# CITY OF ALBUQUERQUE

**Re: Copper Ponte Dialysis Treatment Center  
Erosion and Sediment Control Plan  
Engineer's Stamp Date 10-10-16 (K21E009H1)**

Based upon the information provided in your submittal received 11-14-16, the above referenced plan is not approved to be included in the SWPPP or for ESC Permit until the following comments are addressed:

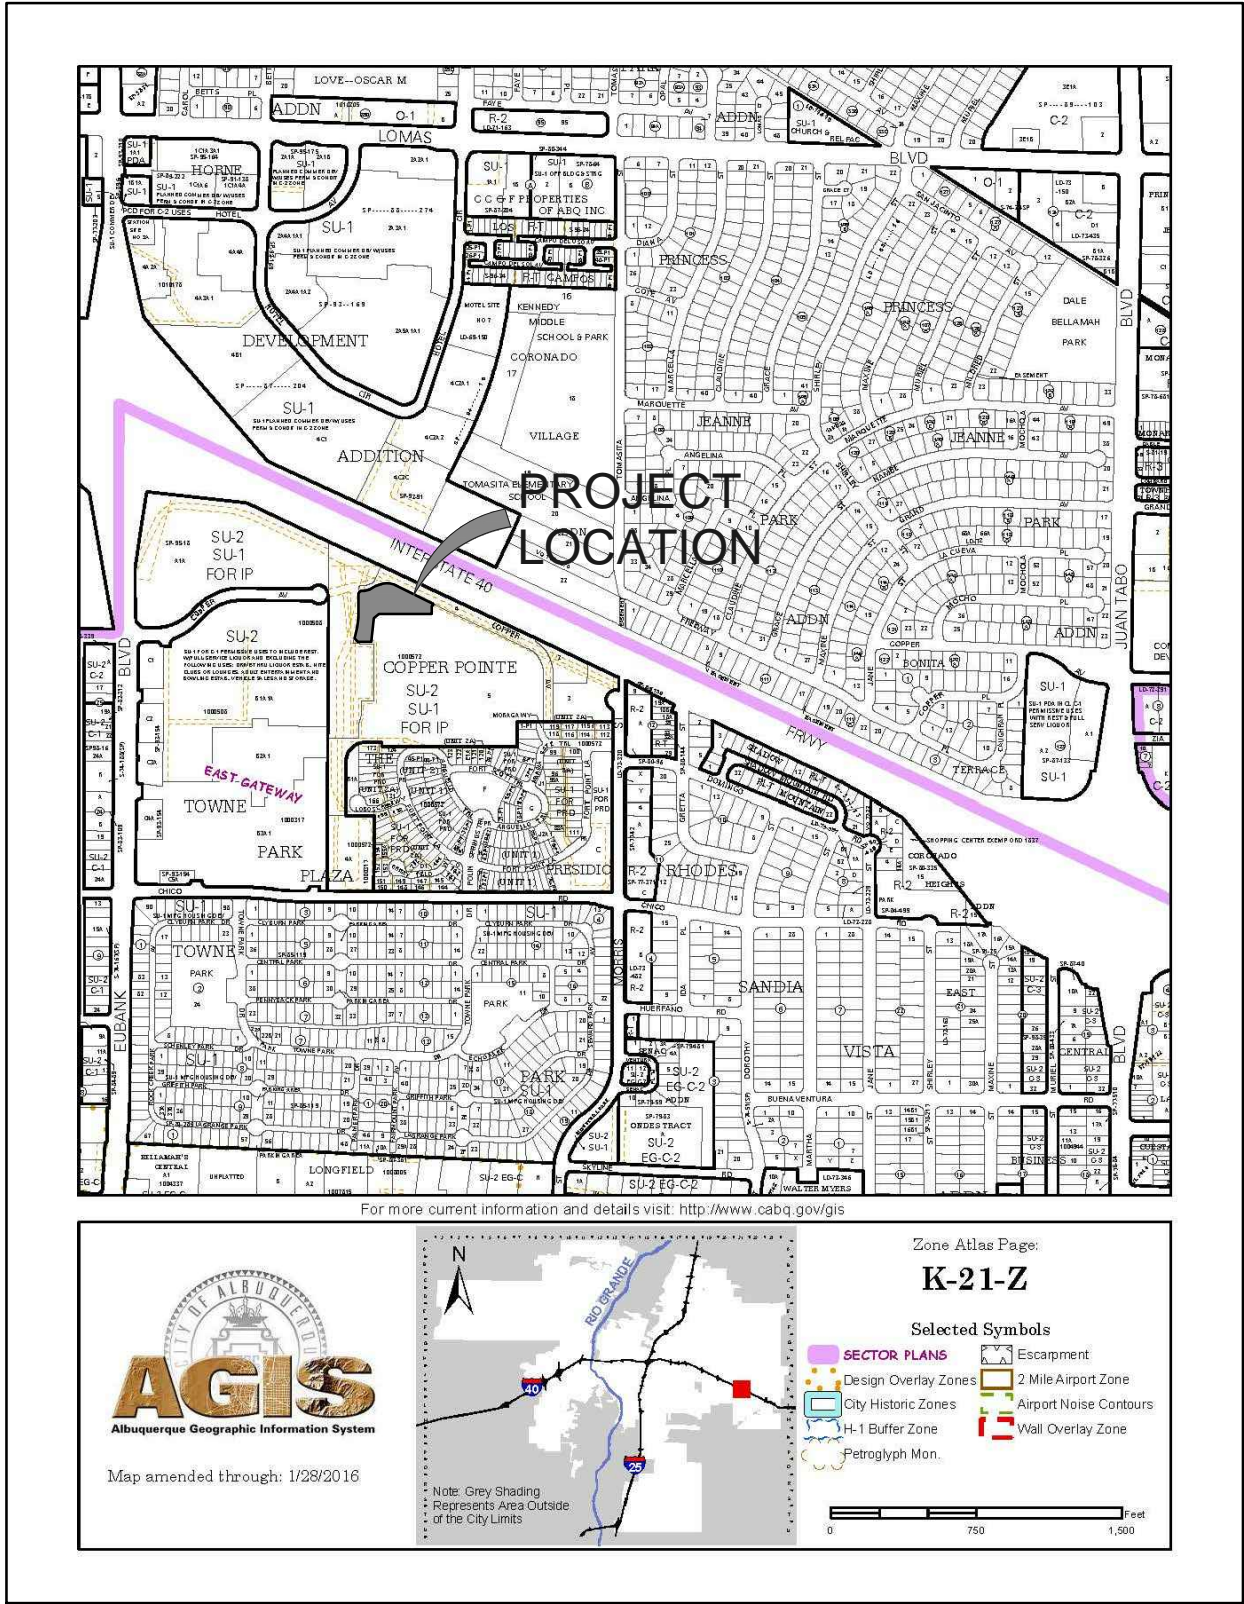
1. Provide details for BMP installation.
2. Provide inlet protection for the inlets on the site's frontage during the ROW work (e.g. sidewalk, drive pads, etc...). Inlet protection should allow water to enter the inlet at higher flow rates. Stormwater Quality can provide suggestions, if requested.

3. The silt fence along the western edge should not extend into the driving lane.
4. Most commercial projects require a utility cut for water/sewer. A sediment BMP is required for the utility cut. Suggested BMP is to provide a note similar to "When cutting the street for utilities add a Keyed Note that the dirt should be placed on the uphill side of the street cut and the area swept after the work is complete."

5. Please add the note "When doing work in the City ROW (e.g. sidewalk, drive pads, utilities, etc...) prevent dirt from getting into the street. If dirt is present in the street, the street should be swept at the end of each day or during the day if rain is imminent or if contractor induces water into the street."

6. Provide a Vicinity Map.
